**WELWYN HATFIELD BOROUGH COUNCIL
EXECUTIVE DIRECTOR - PLANNING, PUBLIC PROTECTION AND GOVERNANCE**

DELEGATED APPLICATION

Application No: 6/2017/0904/HOUSE
Location: 22 Kingswell Ride, Cuffley, Potters Bar, EN6 4LH
Proposal: Extension of existing dormer window to side elevation
Officer: Mr D Elmore

Recommendation: Granted

Proposed Side Elevation

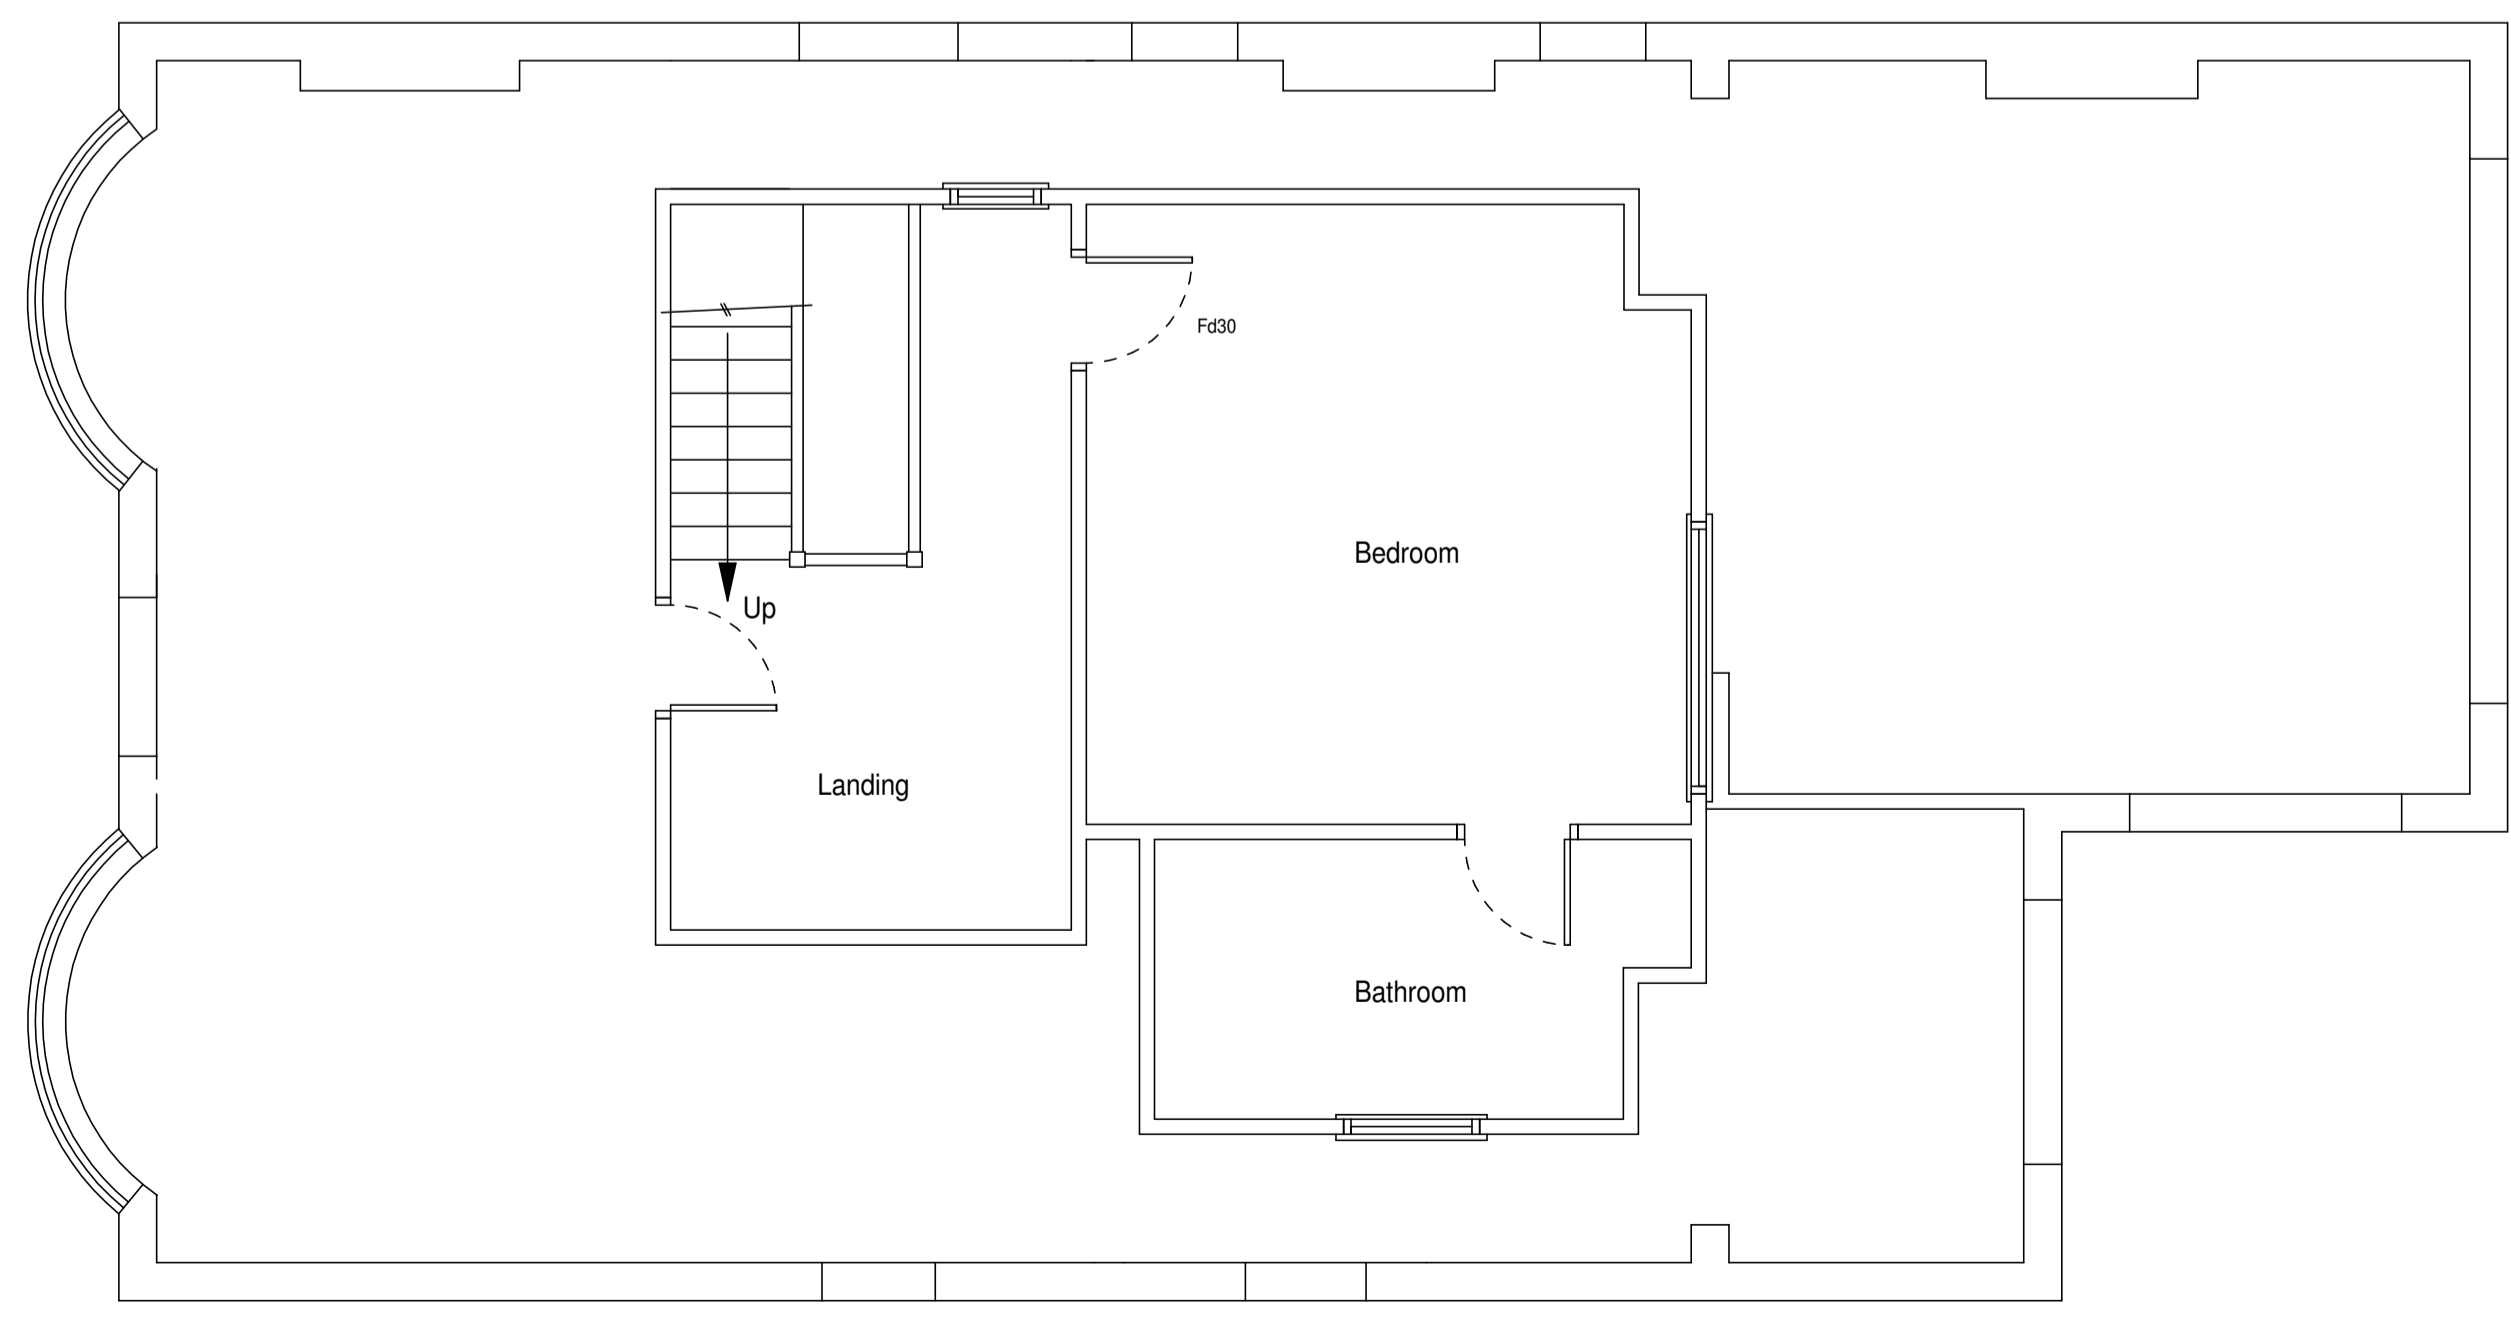
Comment: N/A			
Would the development reflect the character of the area?			
<input checked="" type="checkbox"/> Yes <input type="checkbox"/> No			
Comment: It is proposed under this application to extend the width of an existing dormer window on the western roof slope of subject property. The existing dormer window is set in from the rear gable by 0.6 metres and has a width of 3.3 metres. The proposed dormer would maintain the current set in from the rear gable and have a total width of 6.4 metres. Therefore, the existing width would roughly be doubled.

Although such an increase in its width would be substantial, this dormer would be reflective to the scale of the dormer on the eastern roof slope of the property and be in keeping with other side dormer windows in the immediate locality. Notable examples include: No. 19, 20 & 23 Kingswell Ride. Moreover, proposed dormer would be appropriately set back from the principal hipped roof so as to ensure that it is not overly prominent in the street scene. In light of the above and subject to matching external materials, it is considered, on balance, that the proposed development would be adequately acceptable in design and character terms.

Proposed First Floor Plan

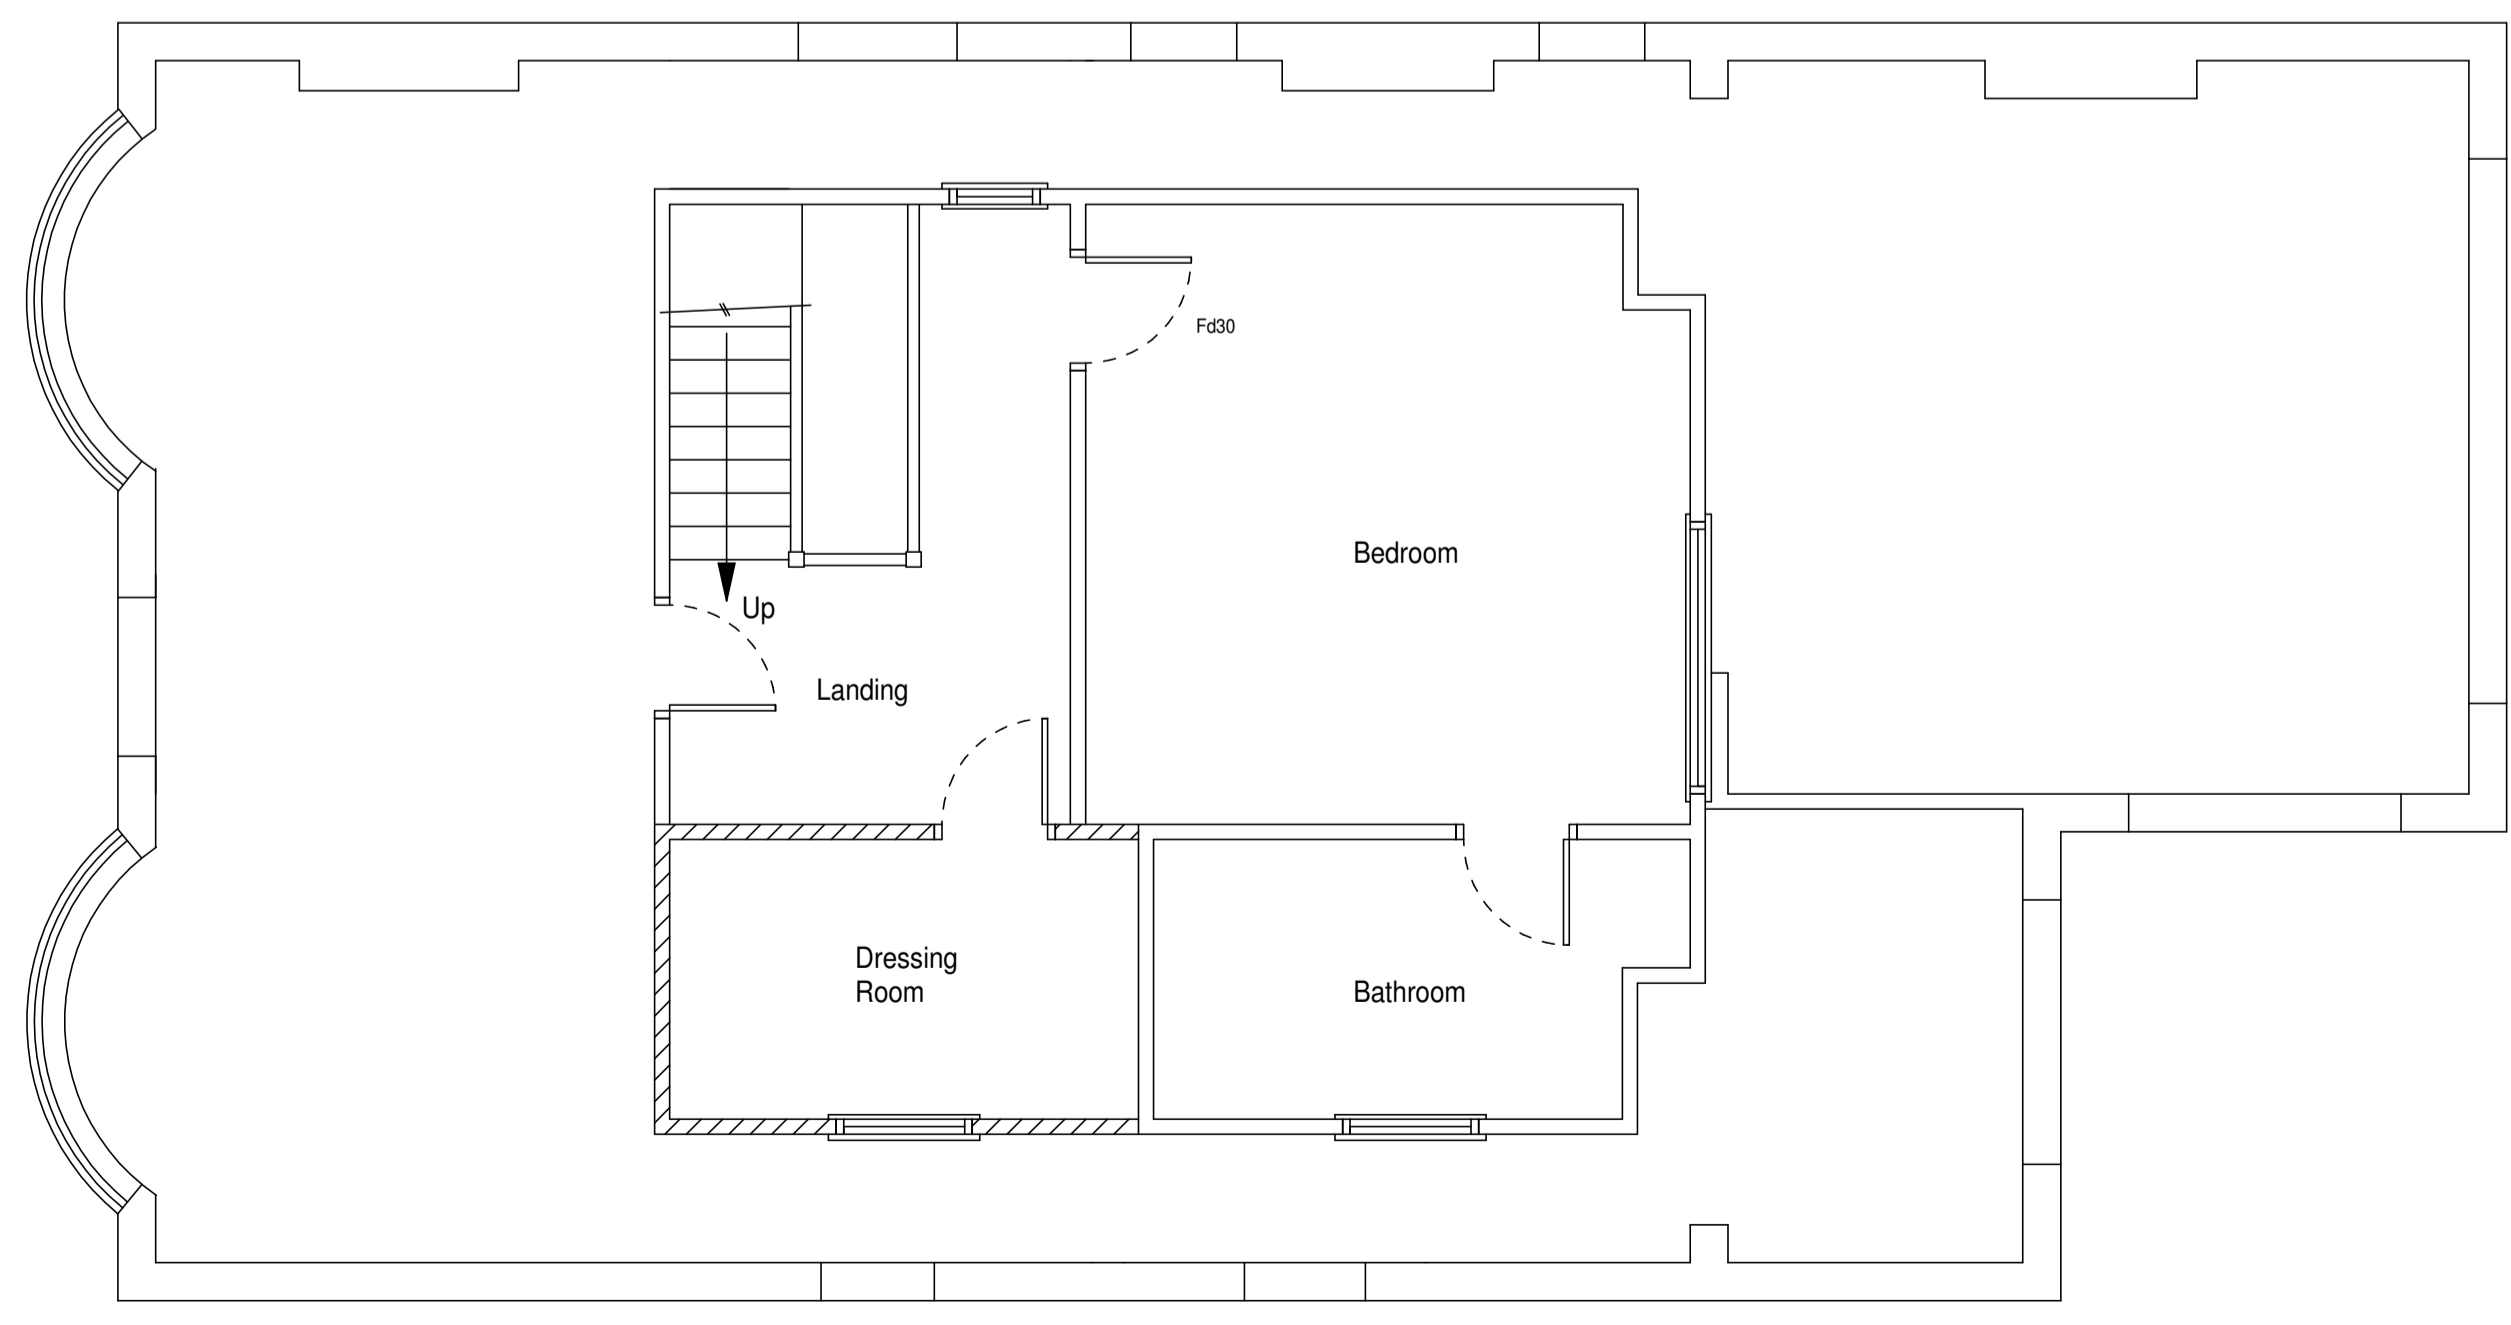
Comment: The existing side dormer features a window facing No. 24 Kingswell Ride. This window serves a bathroom and has been secured under planning condition to be glazed in obscure glass and incapable of being opened below a height of 1.7 metres above internal floor level. The enlarged dormer would feature an additional window facing No. 24 and would serve a dressing room. Given its use and location, it is also considered necessary and reasonable for this window to subject to the same condition in the event of a grant of planning permission. This is to ensure that existing levels of privacy are maintained.

2. The windows of the proposed development facing No. 24 Kingswell Ride shall be glazed with obscured glass and shall be fixed so as to be incapable of being opened below a height of 1.7 metres above floor level, and shall be retained in that form thereafter.
